**Kambala School Sports Precinct Redevelopment (SSD-10385)
Construction Environmental Management Plan, Condition C18**

I refer to the Construction Environmental Management Plan (CEMP) and Sub-plans submitted to the Planning Secretary in accordance with Condition C18 of SSD-10385 (as modified).

Attachment 1

- Legend:
- Site security fence
  - Vehicle movements
  - Pedestrian movements
  - Washdown area
  - Hydrant
  - Buildcorp Site sheds
  - Tower Crane
  - Access road
  - Existing built form
  - New Works
  - Demolition
  - Project Landscape
  - Site Boundary
  - Extent of live School enviroment

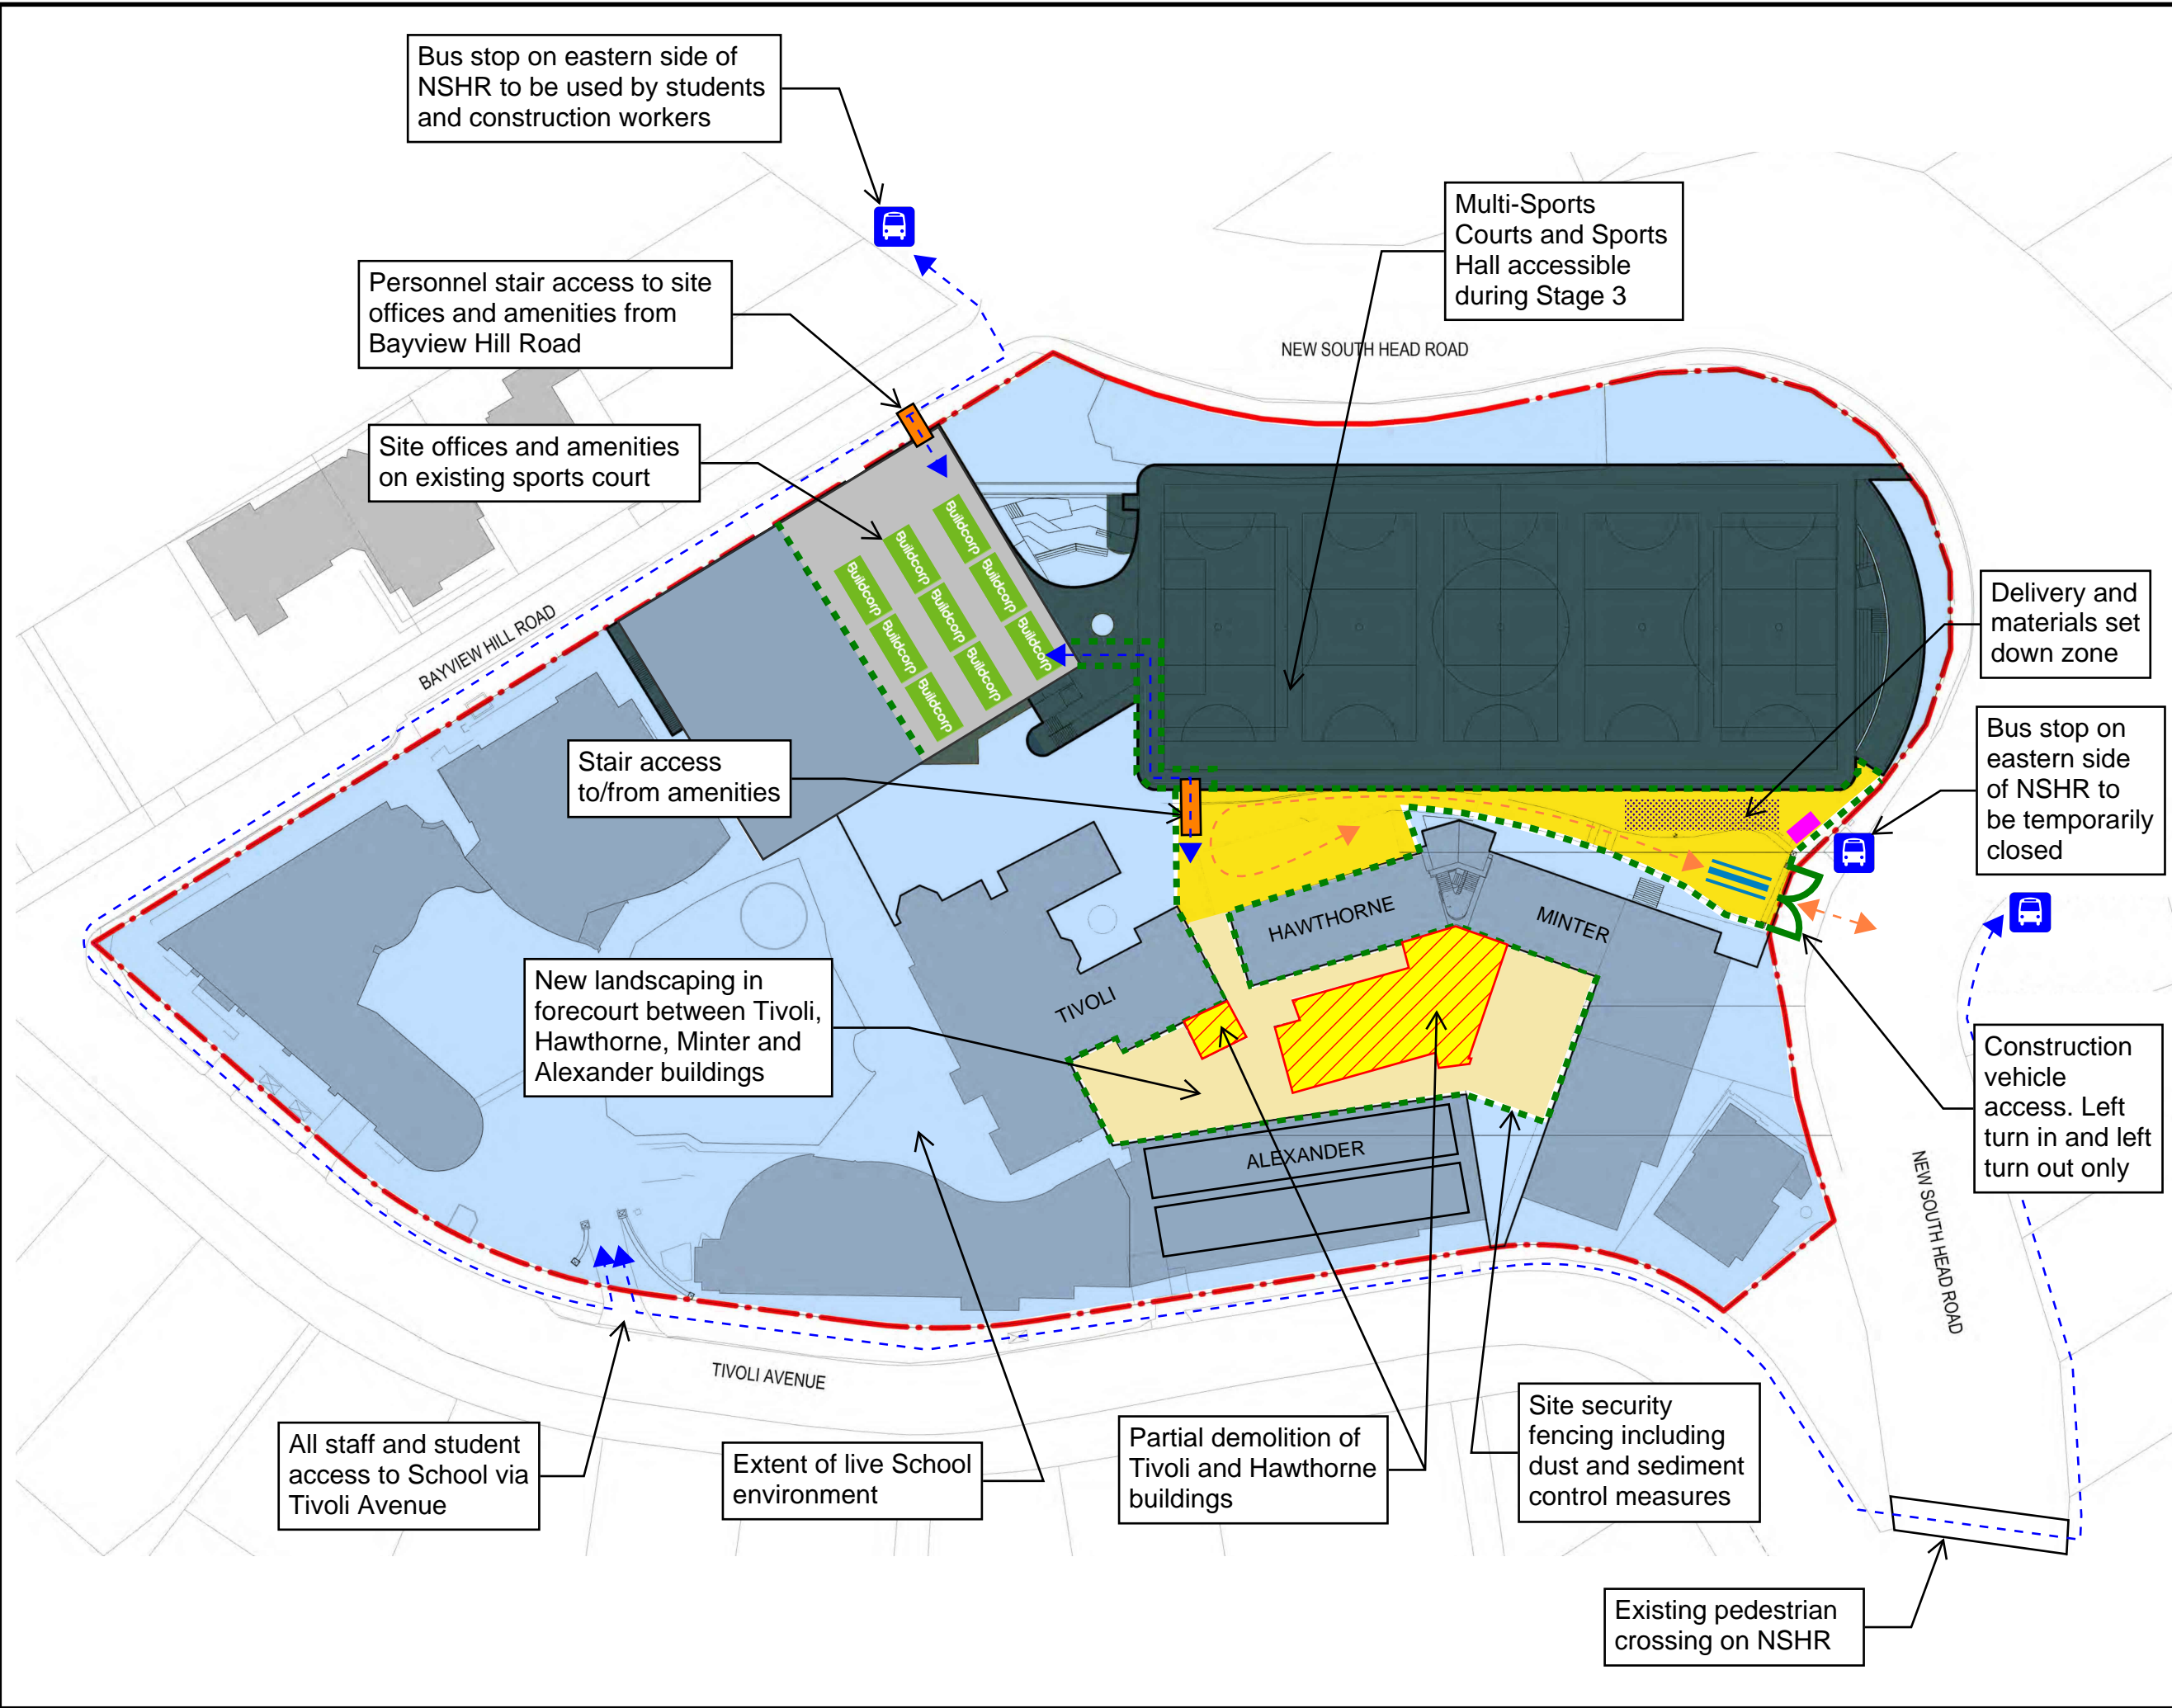
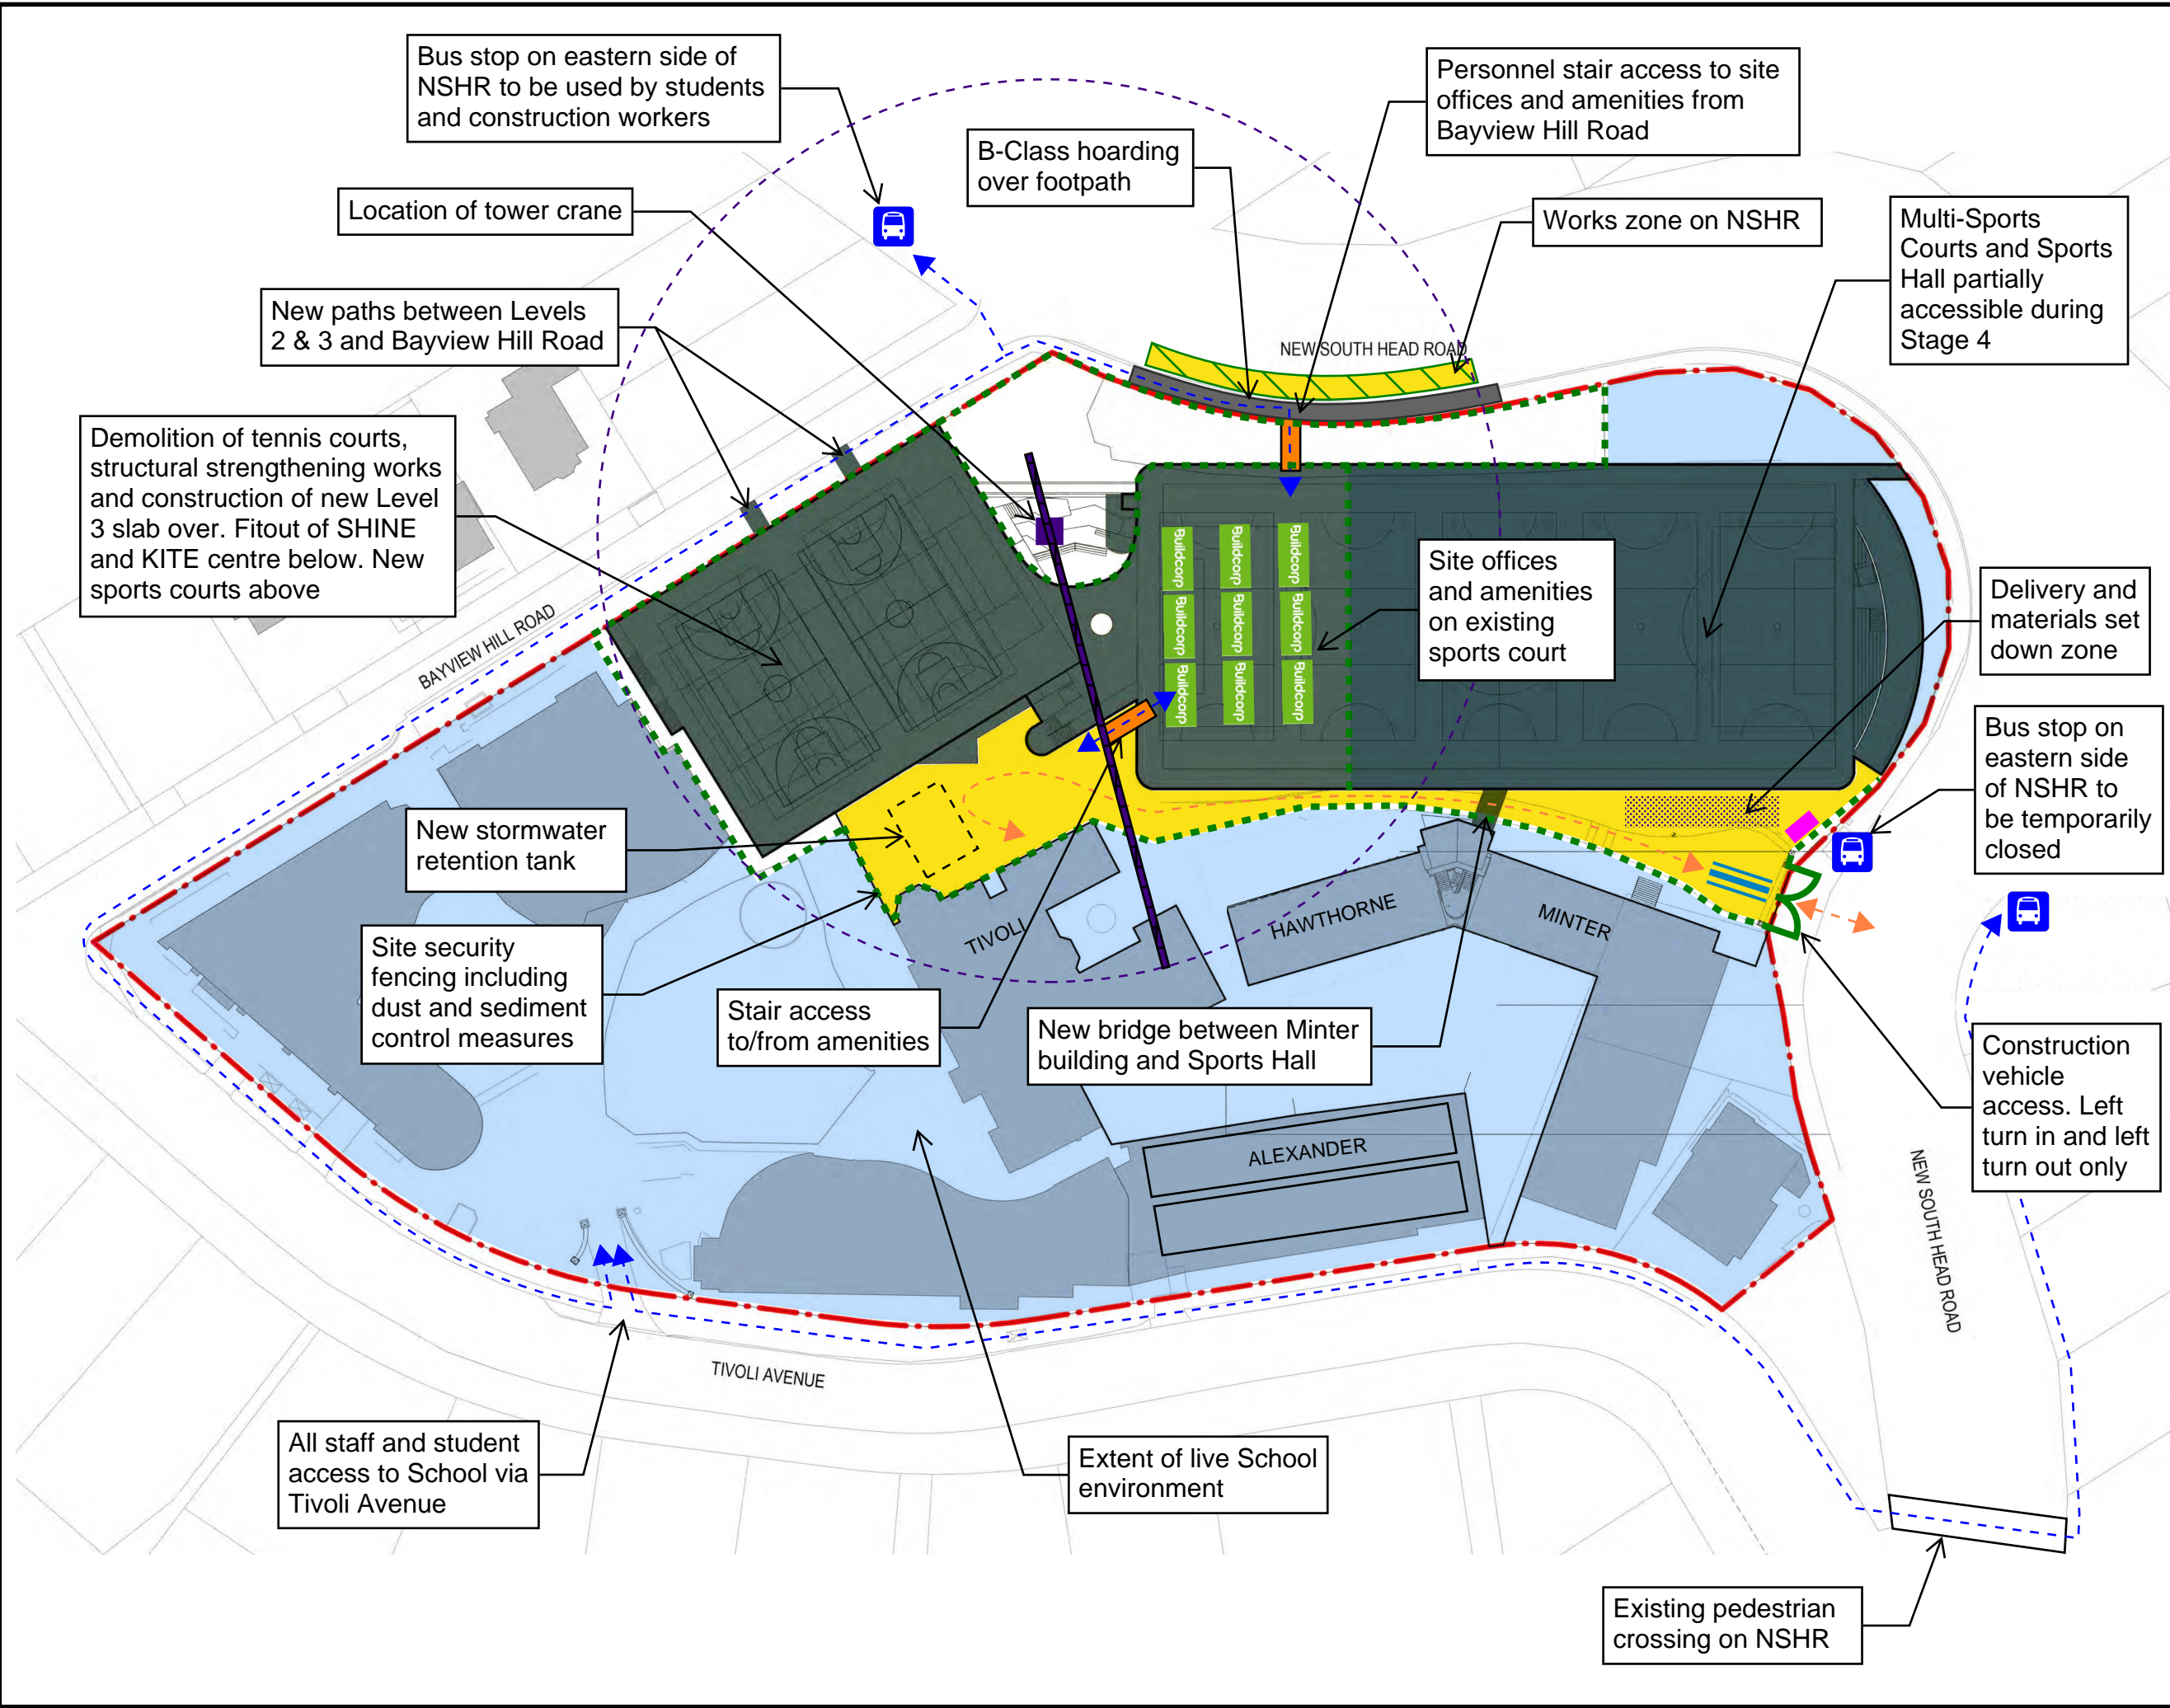
<u>Condition C22</u> The Applicant must prepare a Construction Soil and Water Management Plan (CSWMSP) and the plan must address, but not be limited to the following:	The submitted document to address Condition C22 is an Erosion and Sediment Control Plan (ESCP), Revision C, dated 15 August 2025, prepared by TTW Engineers. The drawings do not comply with the requirements of Condition C22. While the plans are useful, they

do not satisfy the several consultation and management requirements of the condition. As such, the drawings provide an incomplete plan of how the requirements of Condition C22 will be achieved. The Department considers that it is inadequate to rely solely on the ESCP to demonstrate compliance with Condition C22.

The Department recommends preparing a CSWMSP that is fit-for-purpose and explicitly addresses the requirements of Condition C22. In preparing the sub-plan, please consult with Woollahra Municipal Council as required by Condition C22(a).
